EPC STORMWATER REVIEW COMMENTS IN ORANGE BOXES WITH BLACK TEXT

OVERALL ALTERNATIVE LANDSCAPE PLAN

The Shire At Old Ranch
Howells & Old Ranch Road
Colorado Springs, CO

**LS 1**

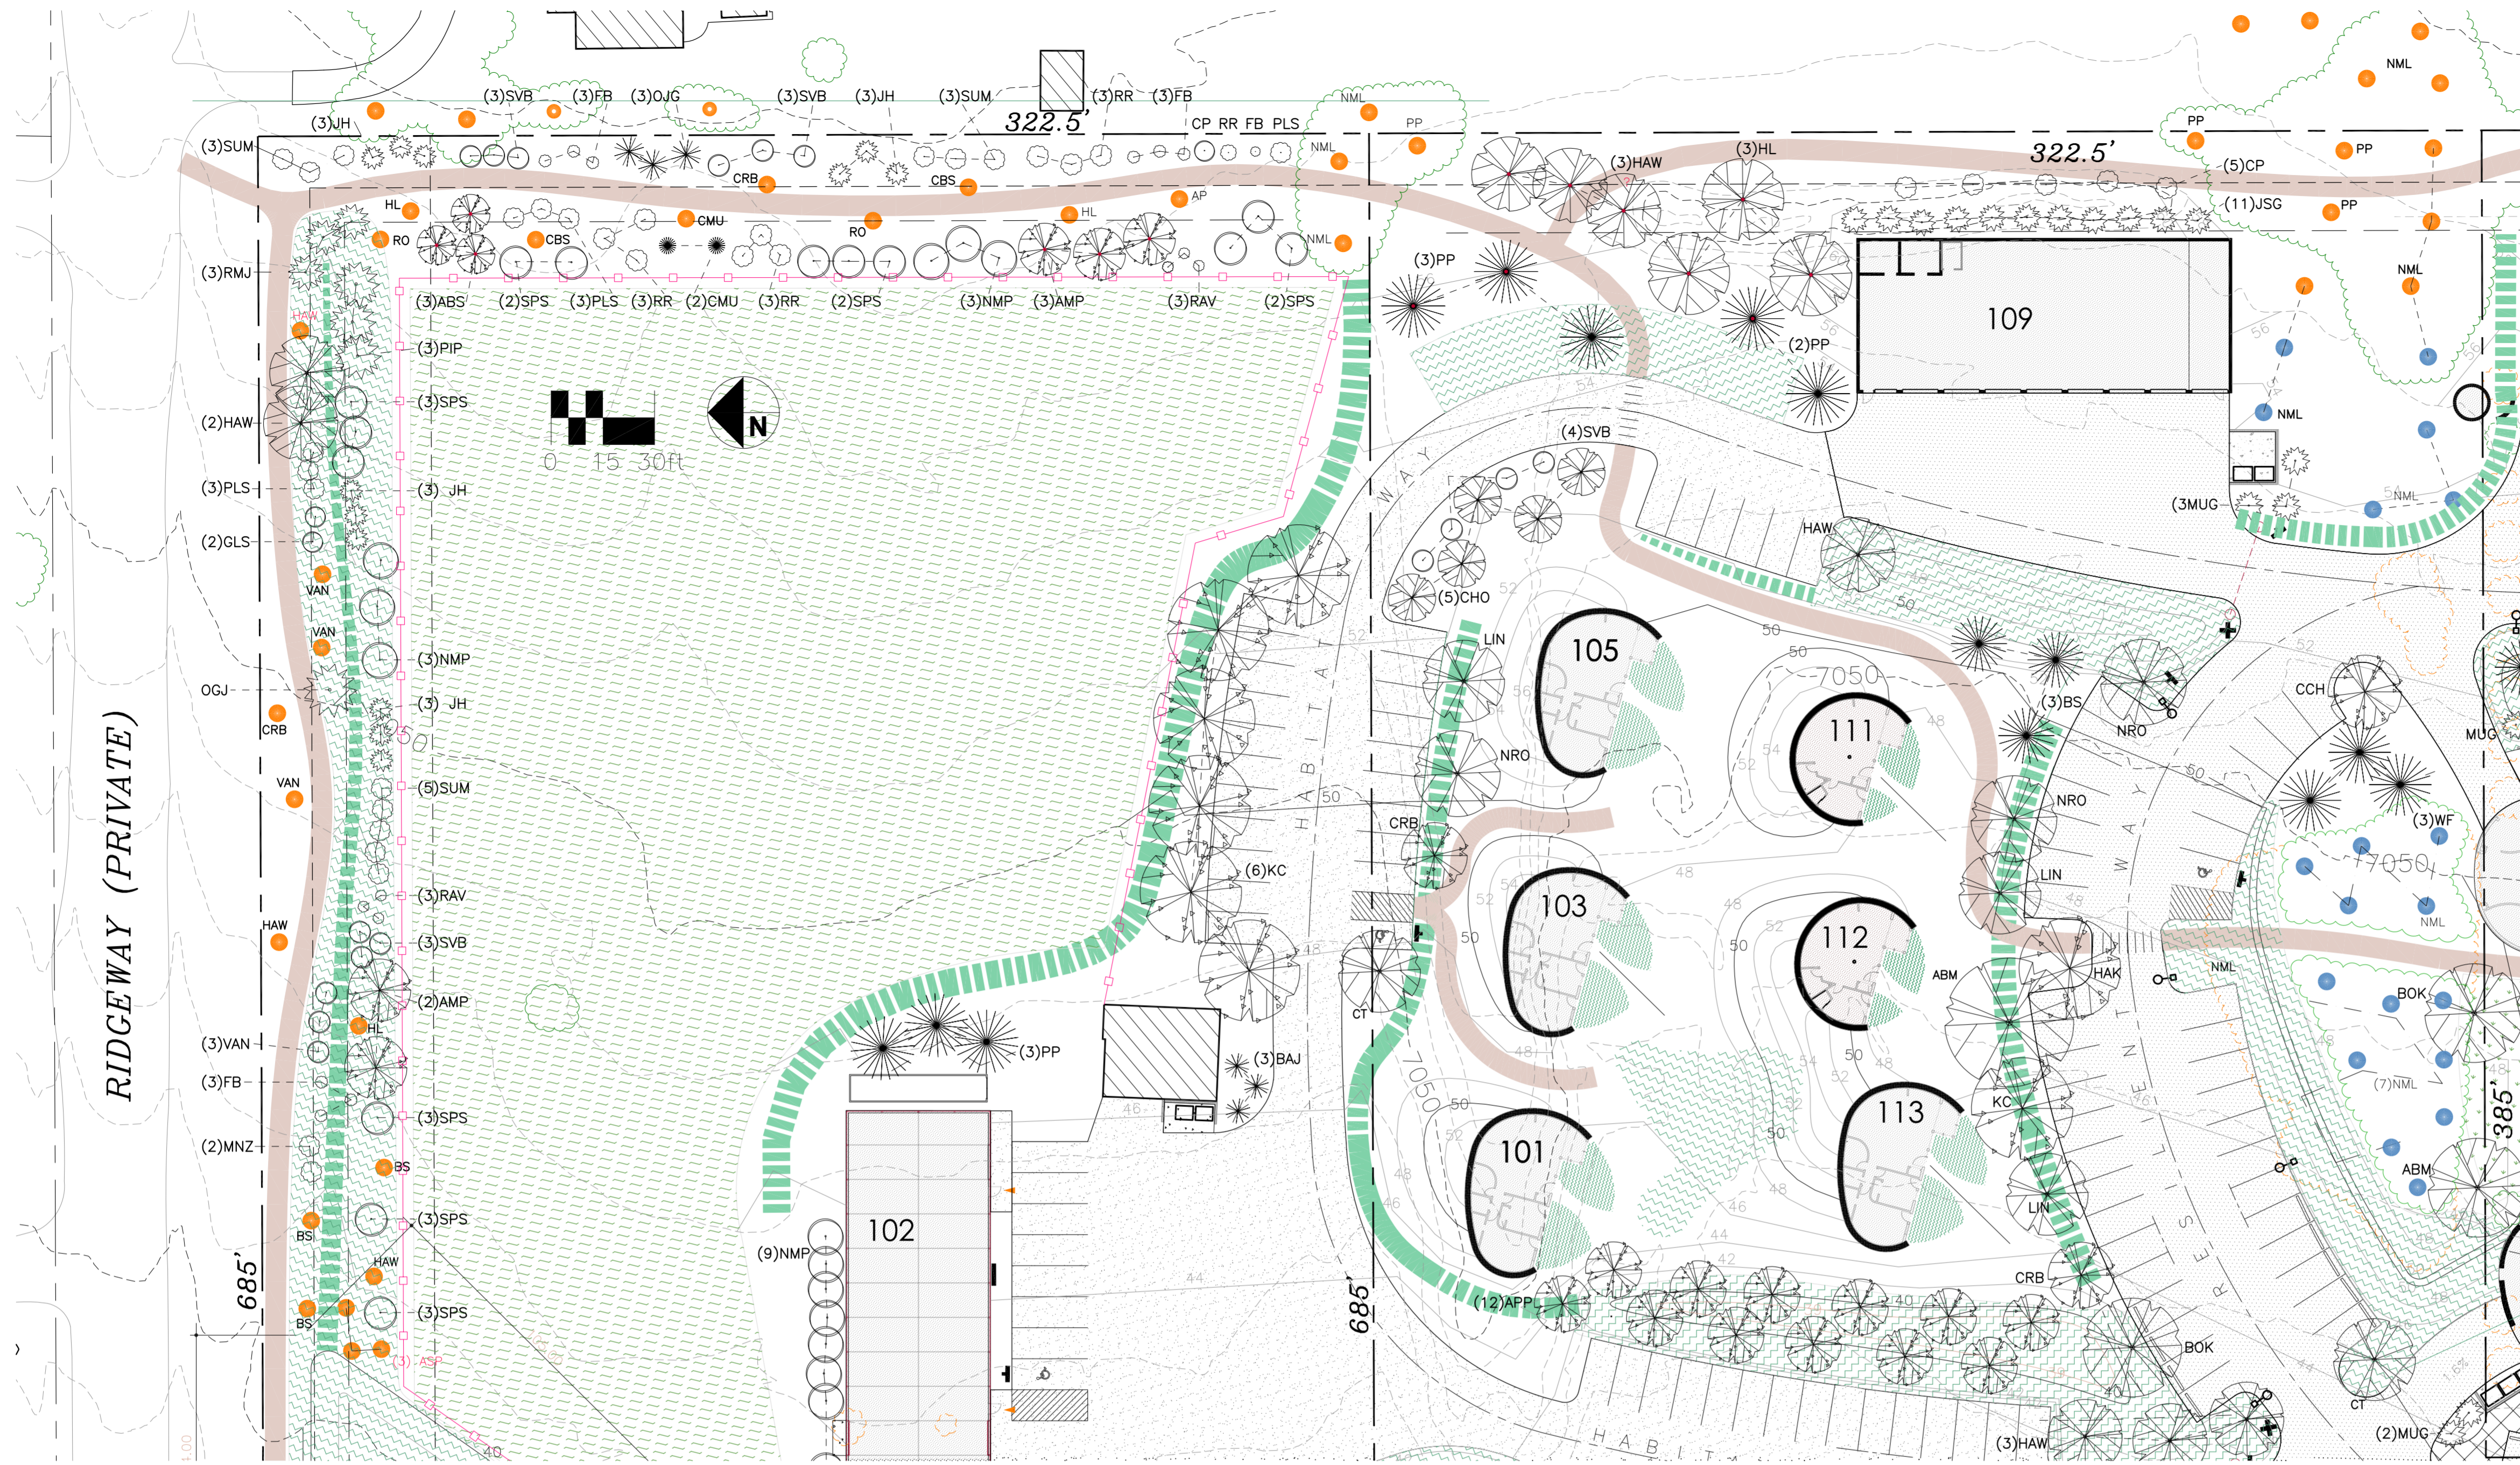
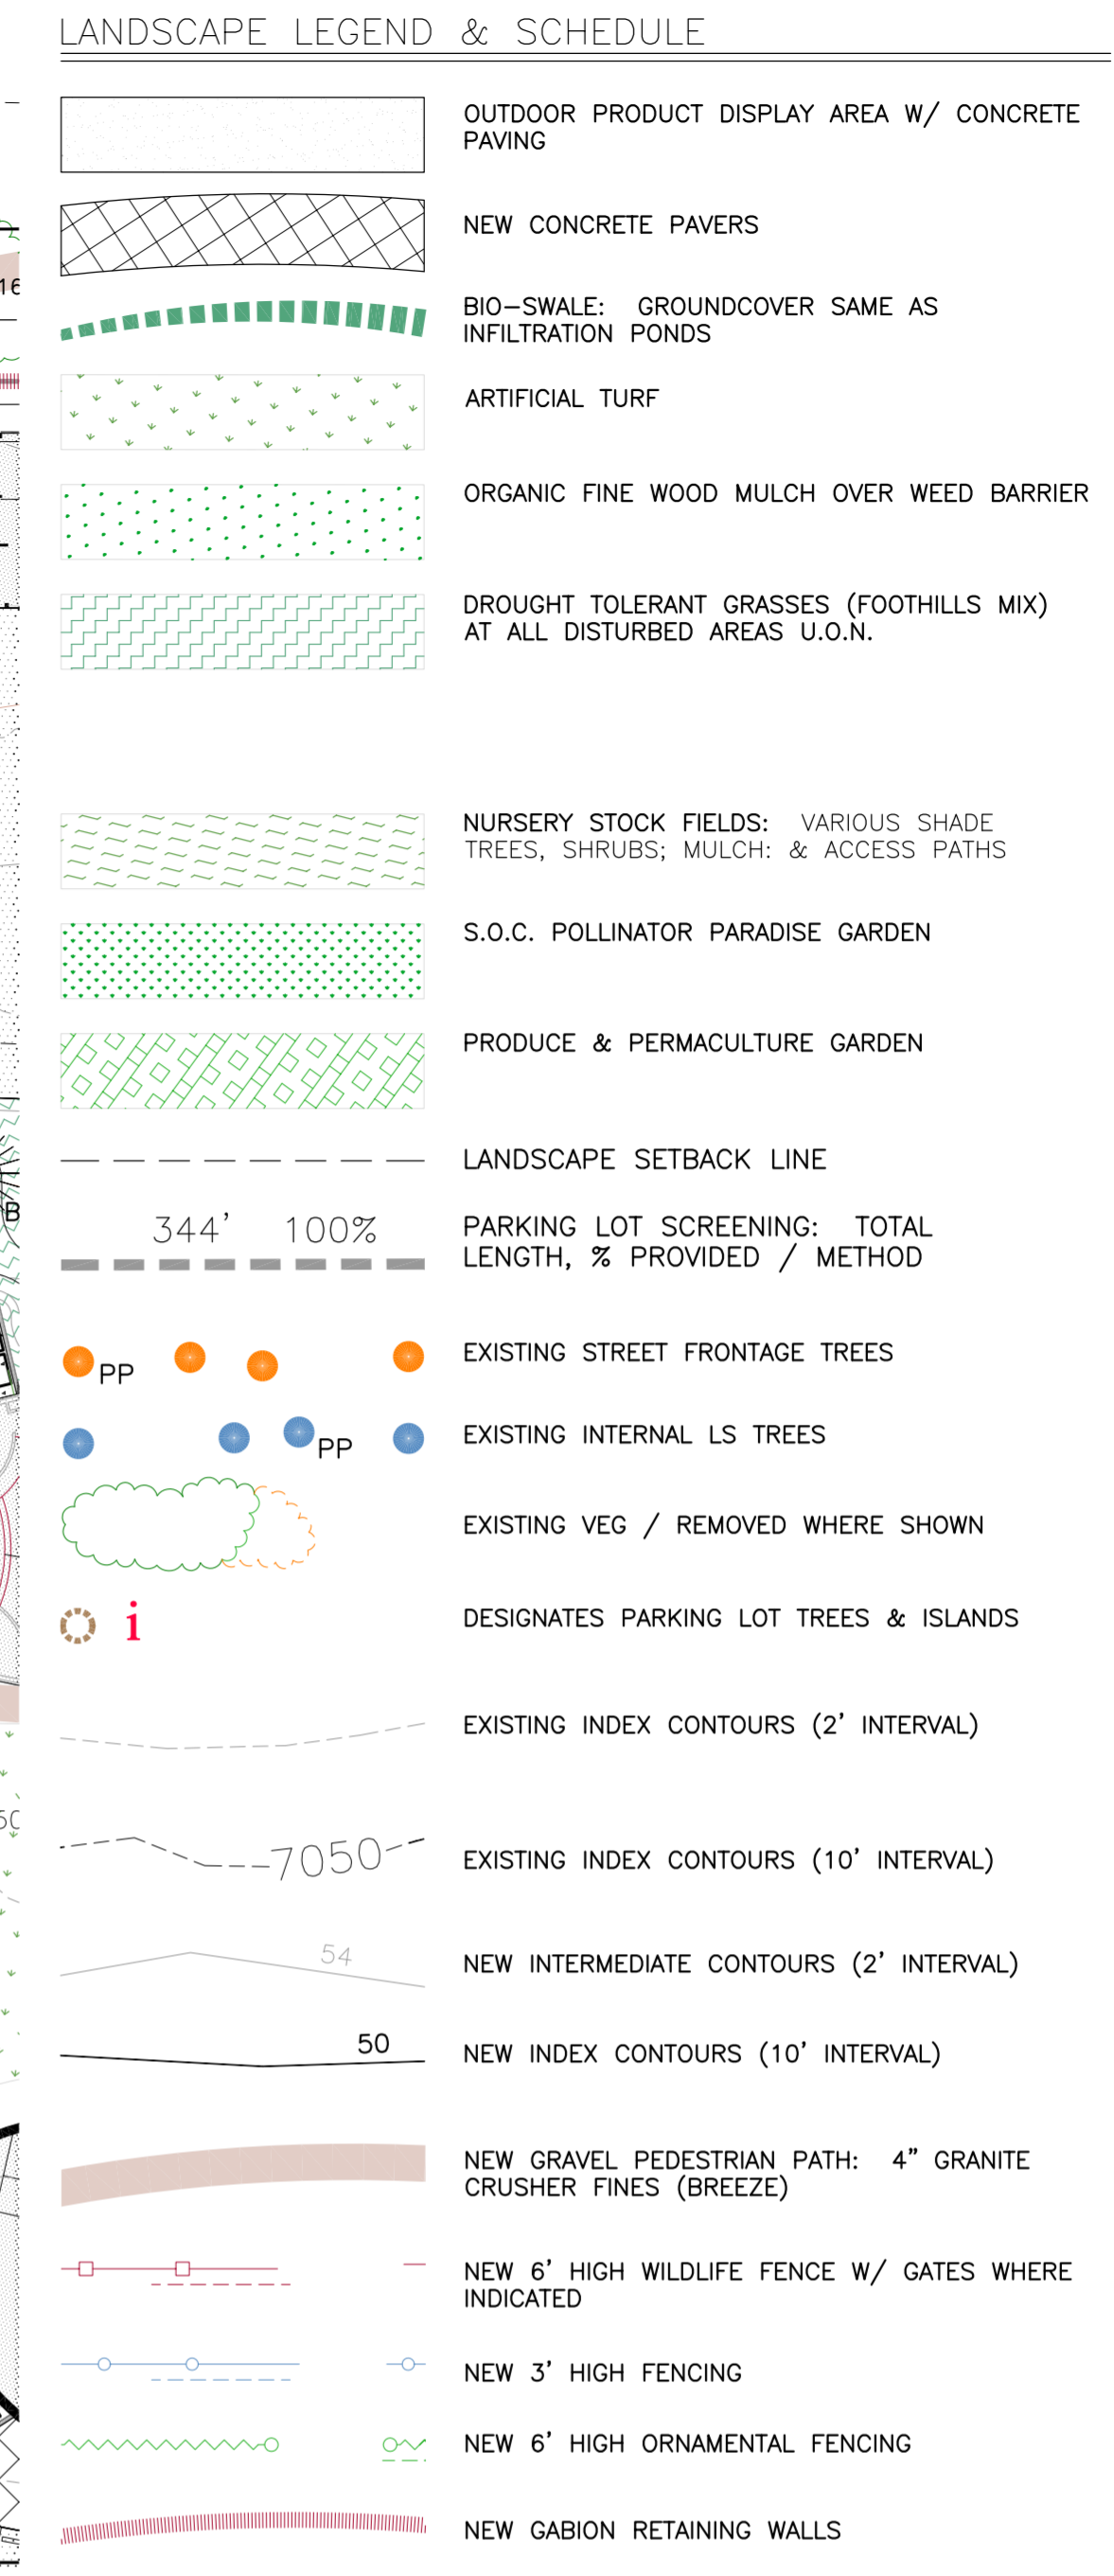
please provide size of islands, per the new code update for landscaping they should be 9 x 18 ft or equivalent of 2 parking spaces

Please depict where all islands are as they relate to this project

These are the same please revise

Please consider using colors that are easier to see on plans such as, red, dark blue, dark purple, bright pink

Please include: File Number: PPR2410

**LS 2**  
 LANDSCAPE PLAN  
 1" = 30'

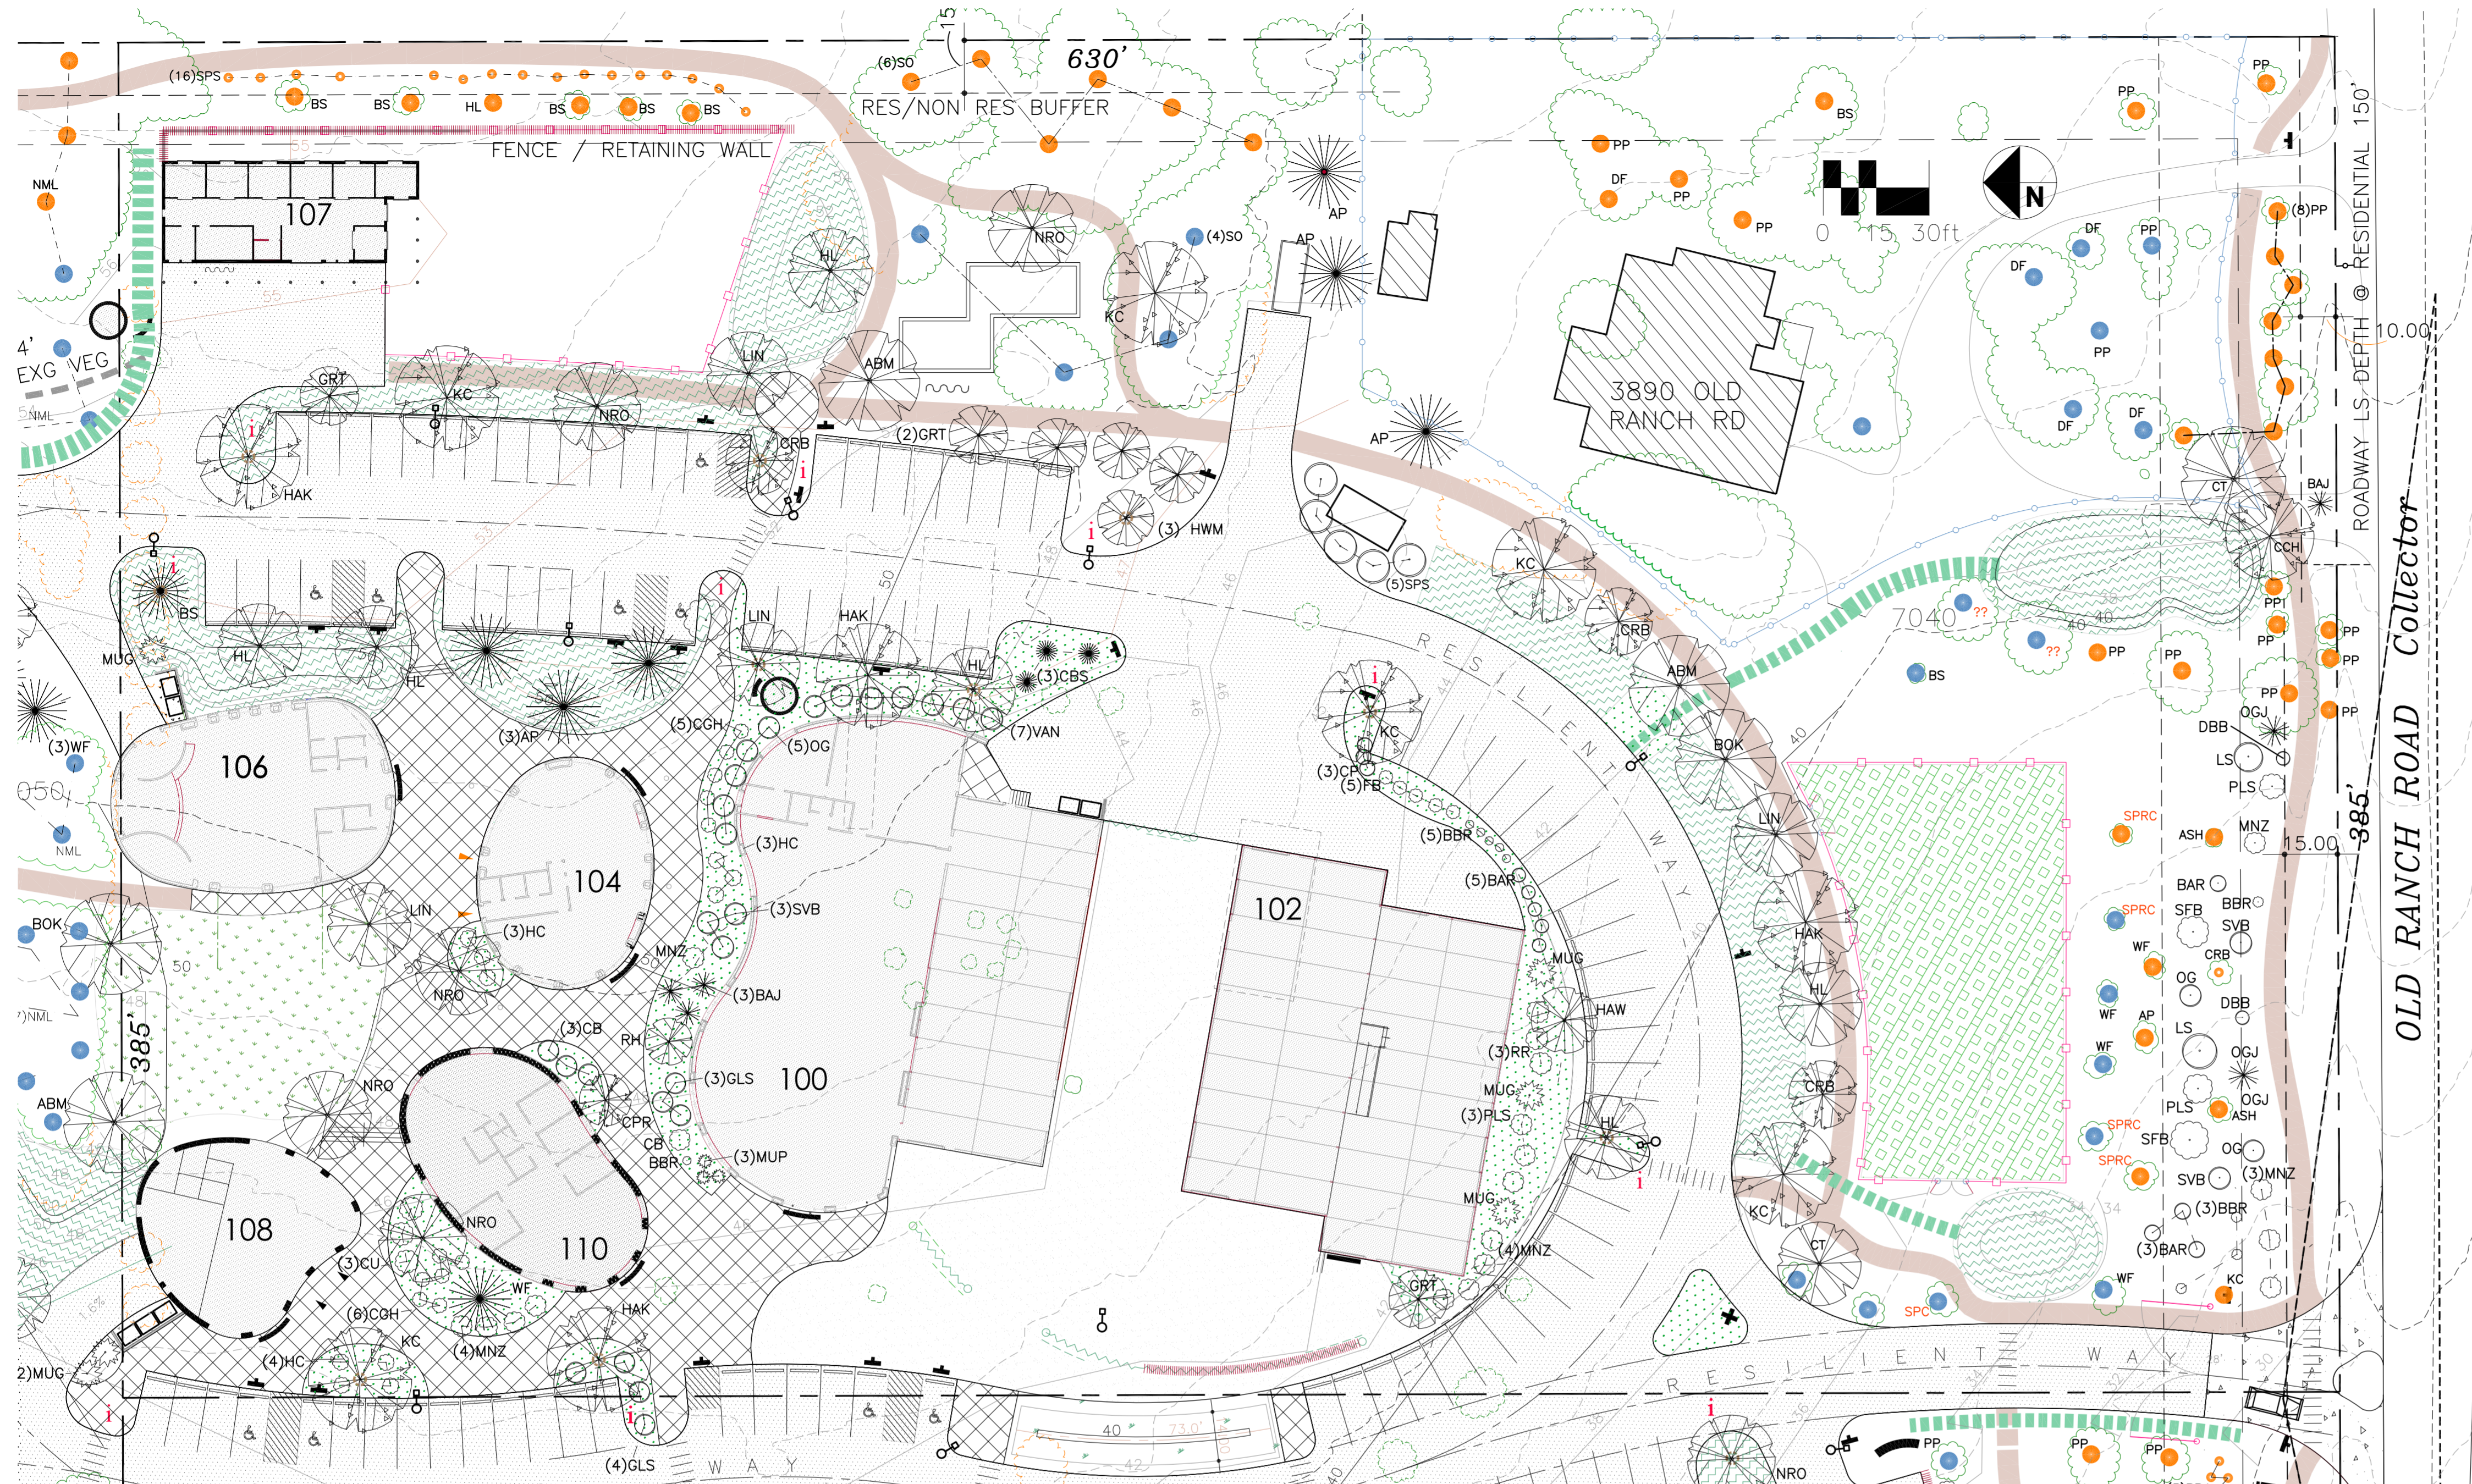
This type of tree is not recommended per the landscape code, please consider planting a different species, what is existing is fine
